Sizewell C (SZC)

Planning Inspectorate Reference: *EN010012*

Deadline 7 – 3 September 2021

East Suffolk Council's (20026200) Response to Examining Authority's Second Round
of Written Questions

DRAWING TITLE:
 BAT ROOST INSPECTION RESULTS 2021
 SHEET 9 OF 14

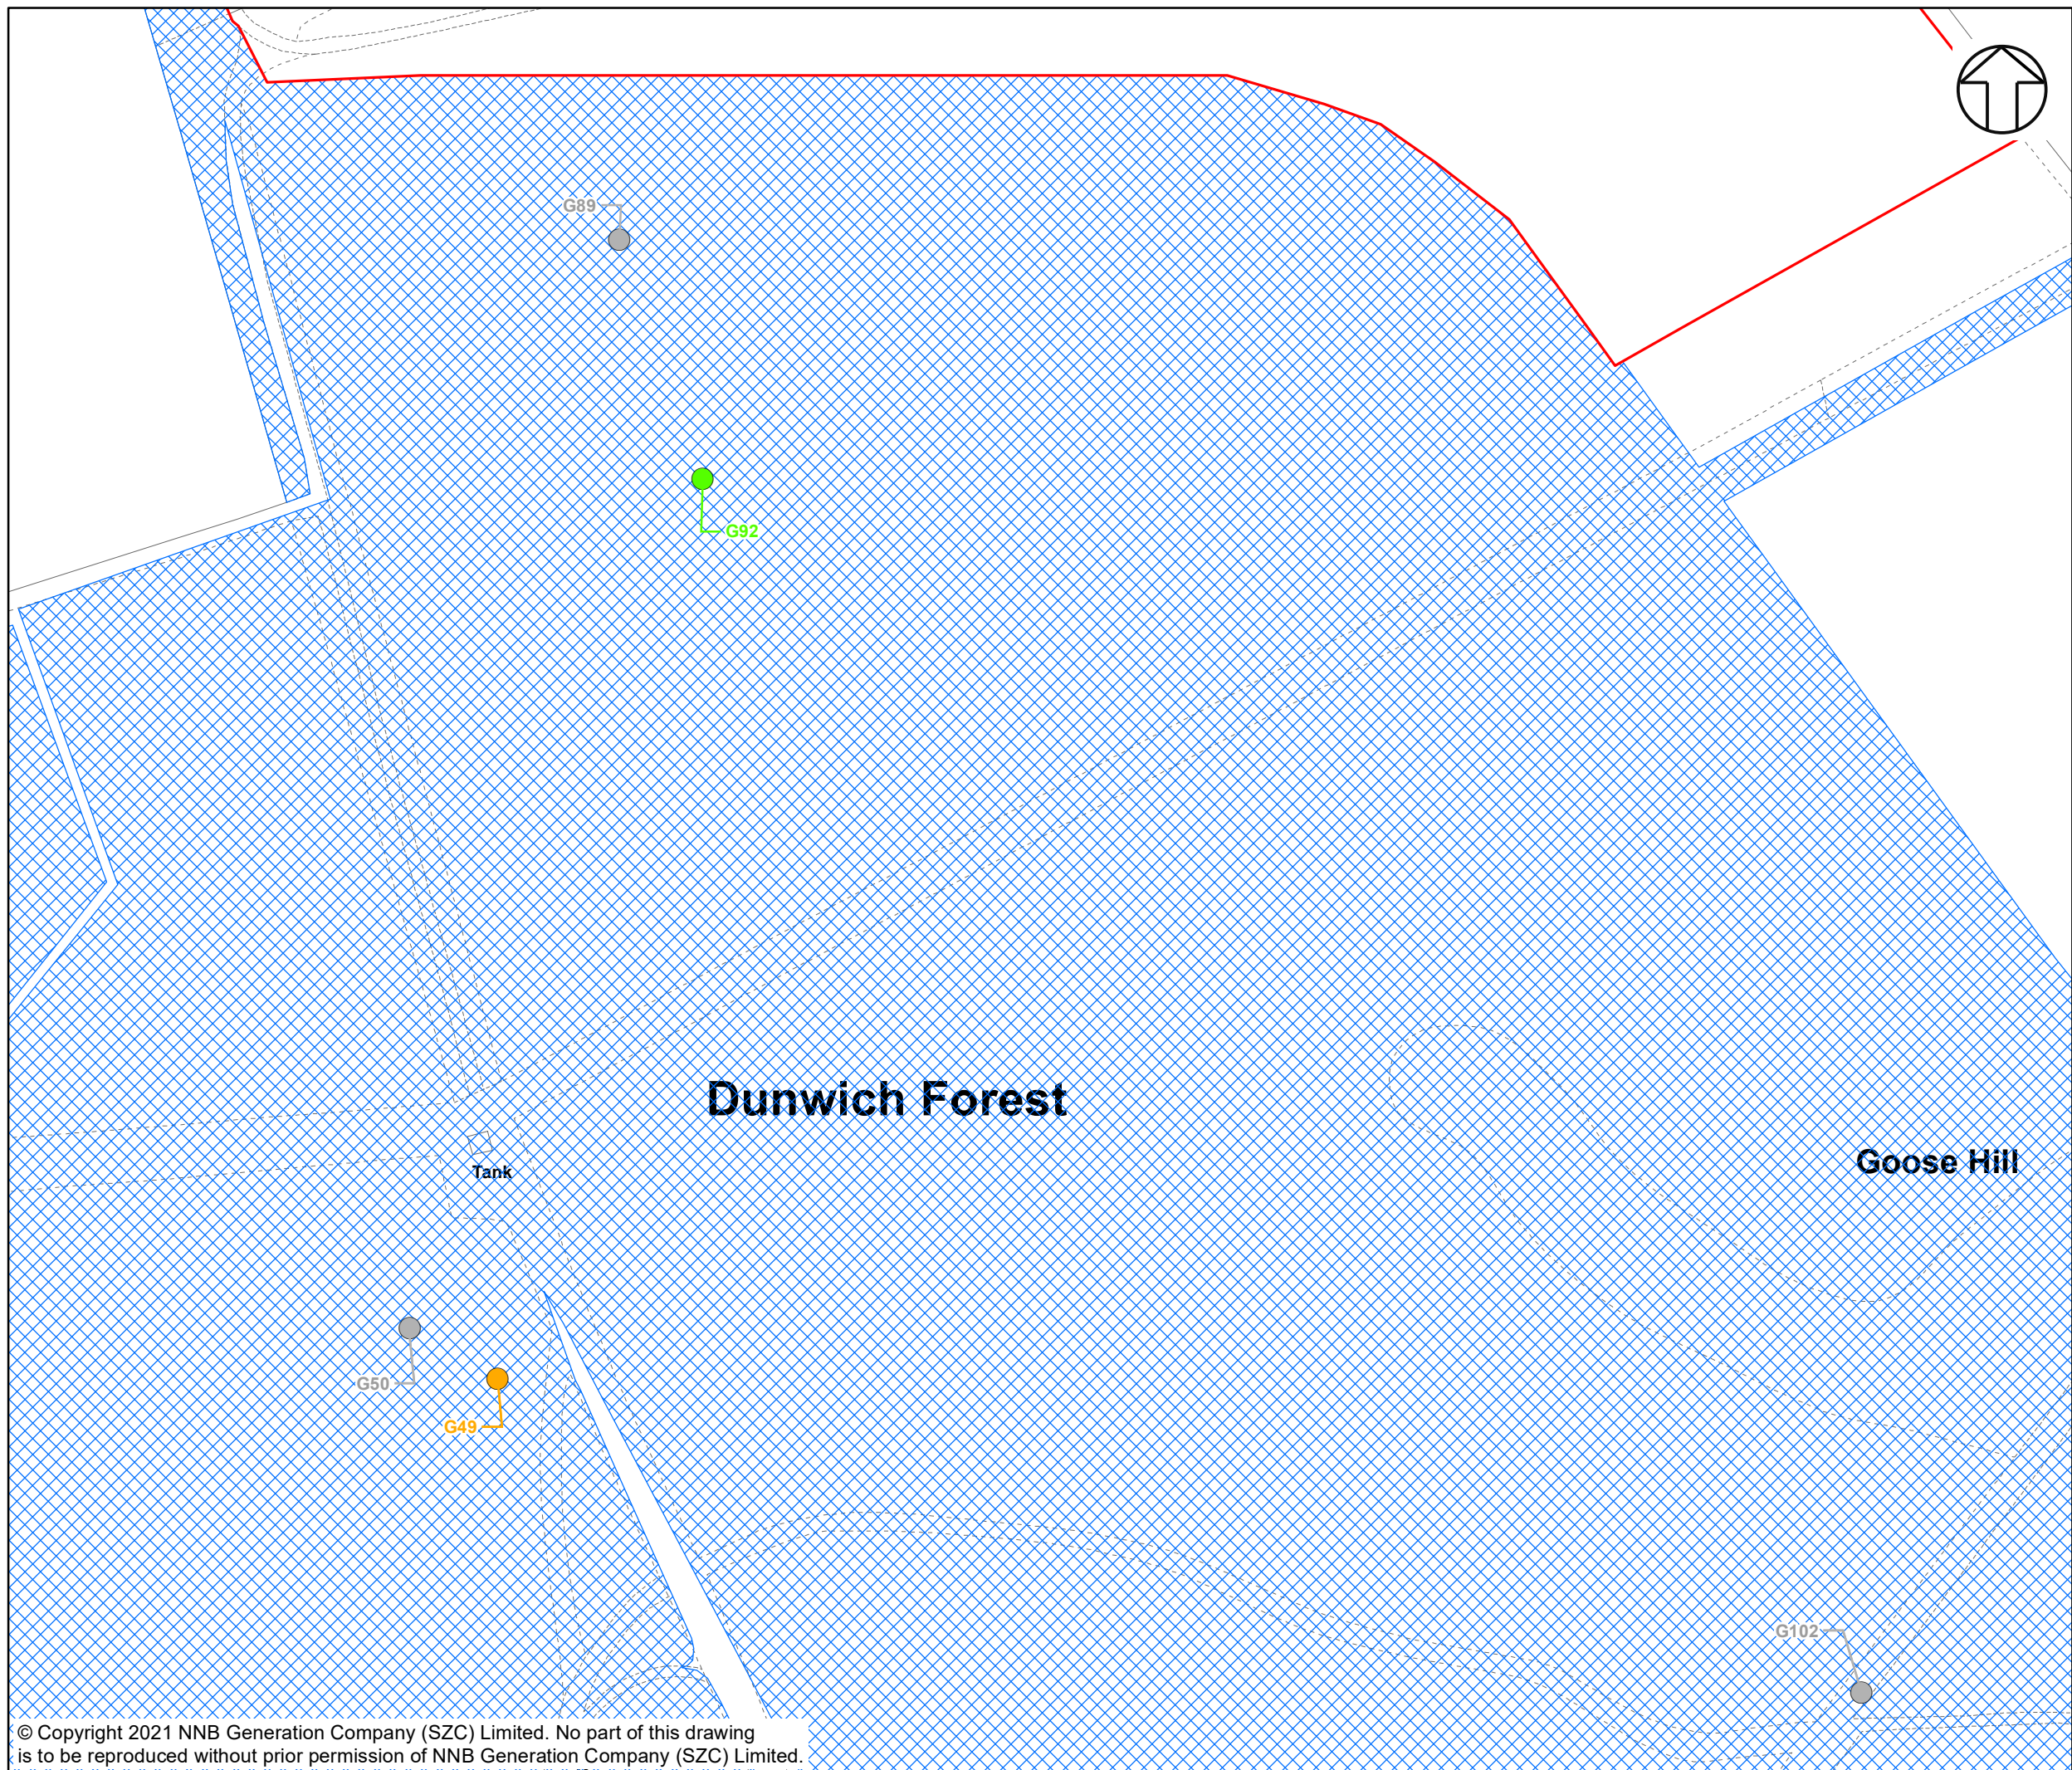
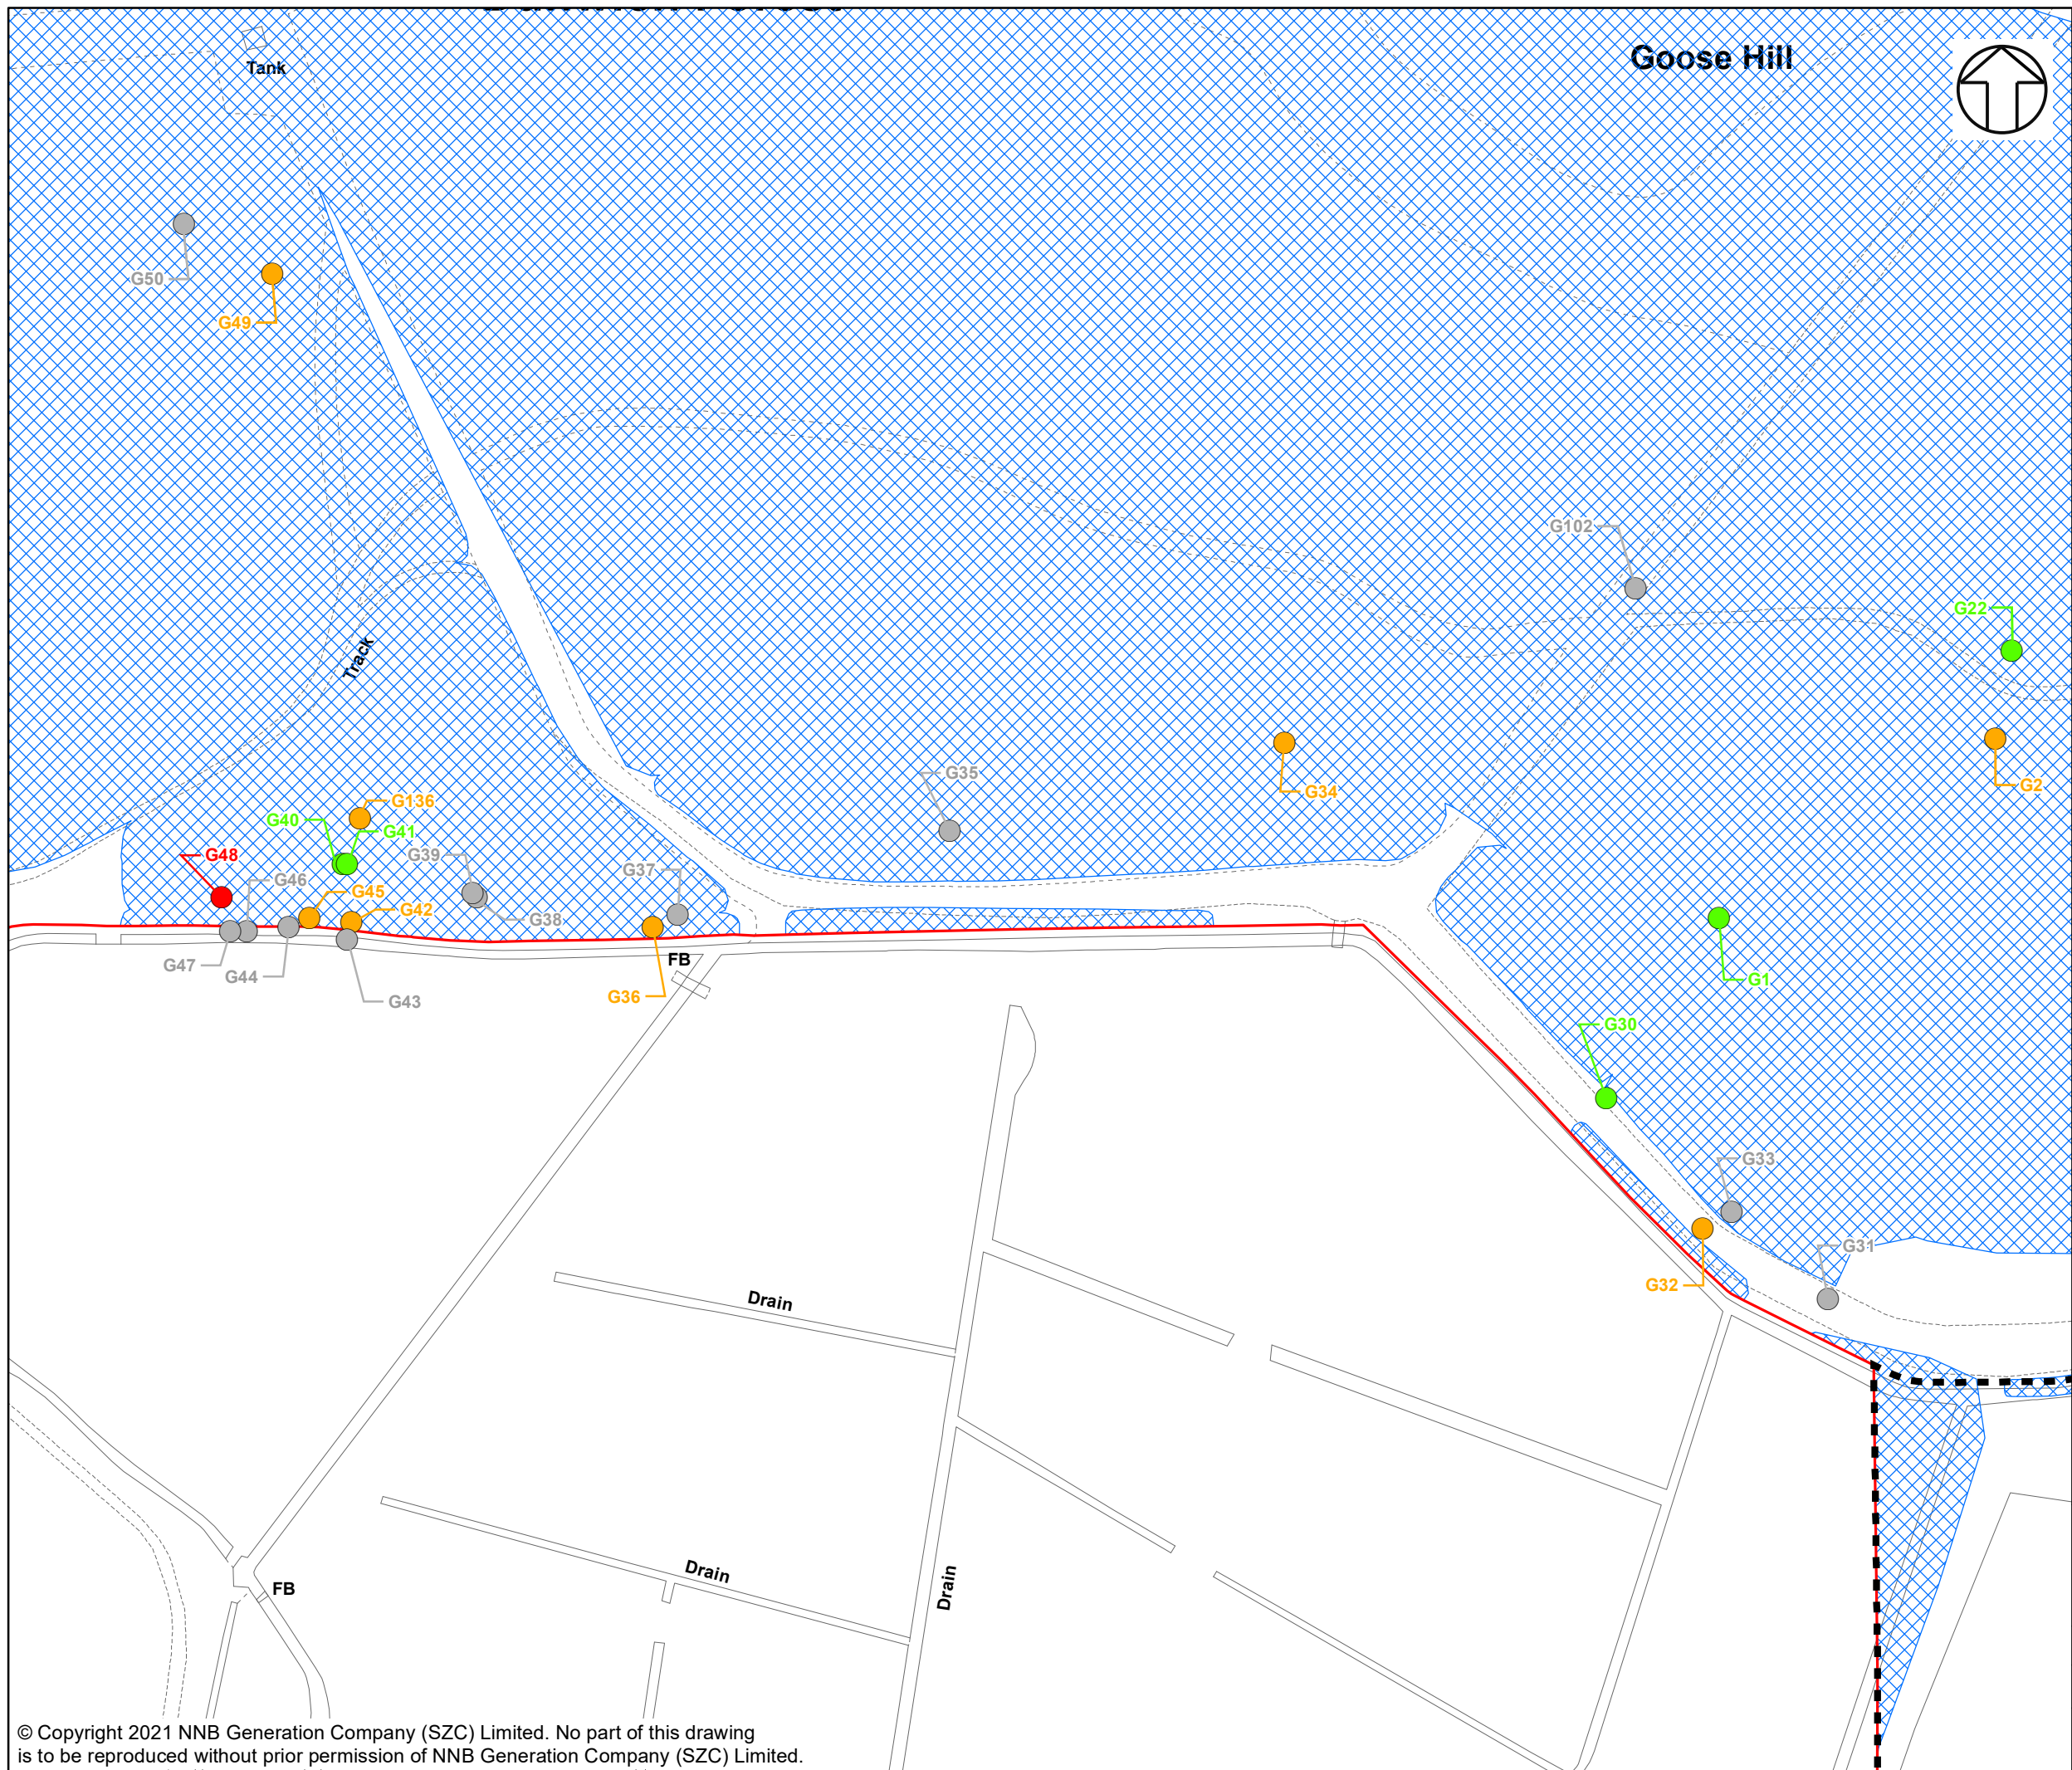
<p>Q9 – The observation by the ExA is a concern shared by ESC and is something that must be resolved, as it essential that implementation of all necessary mitigation measures is adequately secured. In relation to bats, as set out in our Deadline 5 submission [REP5-138] we are particularly concerned that the proposed ‘dark corridors’ for bat connectivity across the Temporary Construction Area (TCA) whilst referenced at multiple points in examination documentation, are not secured in the draft DCO.</p> <p>Q10 – No ESC comment, question to the Applicant.</p>
Bio.2.7	Applicant, ESC	In relation to bat roosts at Goose Hill, there is a dispute between the Applicant and ESC; ESC maintains that the ES and the Updated Bat Impact Assessment [AS-208] contradict each other (see LIR para 8.53). There is considerable detail about tree counts. What progress is there on resolving this?	<p>At Deadline 3 the Applicant provided their 2021 survey results for trees with bat roost potential on the Main Development Site [REP3-035]. ESC provided comments on this report in our Deadline 5 submission [REP5-138]. Since these submissions the Applicant and ESC have continued to engage on this matter.</p> <p>Whilst ESC maintains that contradiction does exist between the ES and the Updated Bat Impact Assessment (possibly due to the evolution of information between the preparation of the two documents), we also note that the 2021 survey report provides additional information in relation to the numbers of bat roost features in Goose Hill and that additional mitigation measures are to be proposed as part of the Natural England licence (please see our answer to question Bio.2.5 above in relation to this). Notwithstanding our comments on</p>

the 2021 survey report submitted in [REP5-138] (which are primarily related to concerns about surveying of trees in other parts of the MDS), it appears likely that the 2021 survey report provides a reasonably accurate assessment of the trees with bat roost potential in Goose Hill.
Part 3 - Matters to be dealt with in writing following ISH7 – Designated sites - No Questions for ESC			
Part 4 - Matters to be dealt with in writing following ISH7 – Sabellaria Spinulosa			
Part 5 – matters arising from the Applicant’s replies to ExQs1 [REP2-100]			
Bio.2.19	Applicant, ESC	<p>Bio.1.78. (a) The Applicant states that the mitigation or enhancements for associated development on sites on third party land are to be secured in the Deed of Obligation. Why are they not in the DCO?</p> <p>(b) For measures on the main development site the measures “would remain within EDF Energy ownership and control”. “EDF Energy”, an undefined entity in the response, is neither the proposed undertaker nor the Applicant. However, if all the measures are secured pursuant to requirements, which the ExA understands from the preceding parts of the Applicant’s response is the case, it will be for the undertaker to ensure that it has the necessary rights to carry out the mitigation on the land of “EDF Energy”, or any other landowner. Please will the Applicant and ESC confirm that this is also their understanding and</p>	<p>ESC notes the limited land that is currently owned by the Applicant (although we understand the group of companies of which the Applicant is part owns the main site). The Applicant is yet to provide ESC with any title to the order land or any details for the proposed structure of land acquisition for the order land.</p> <p>ESC’s general position in relation to the mitigation for associated development on sites on third party land is that, where possible, this should be secured in the DCO and it is the undertaker’s responsibility to ensure that it has the necessary rights to carry out the mitigation on the land, regardless of who owns it.</p> <p>ESC is open to consideration of binding the undertaker rather than the landowner/prospective landowner in respect of the commitments proposed to be included in the Deed of Obligation, so long as such a vehicle is no less effective and has no fewer remedies than the conventional vehicle provided under section 106. We have set out at [REP3-061]</p>
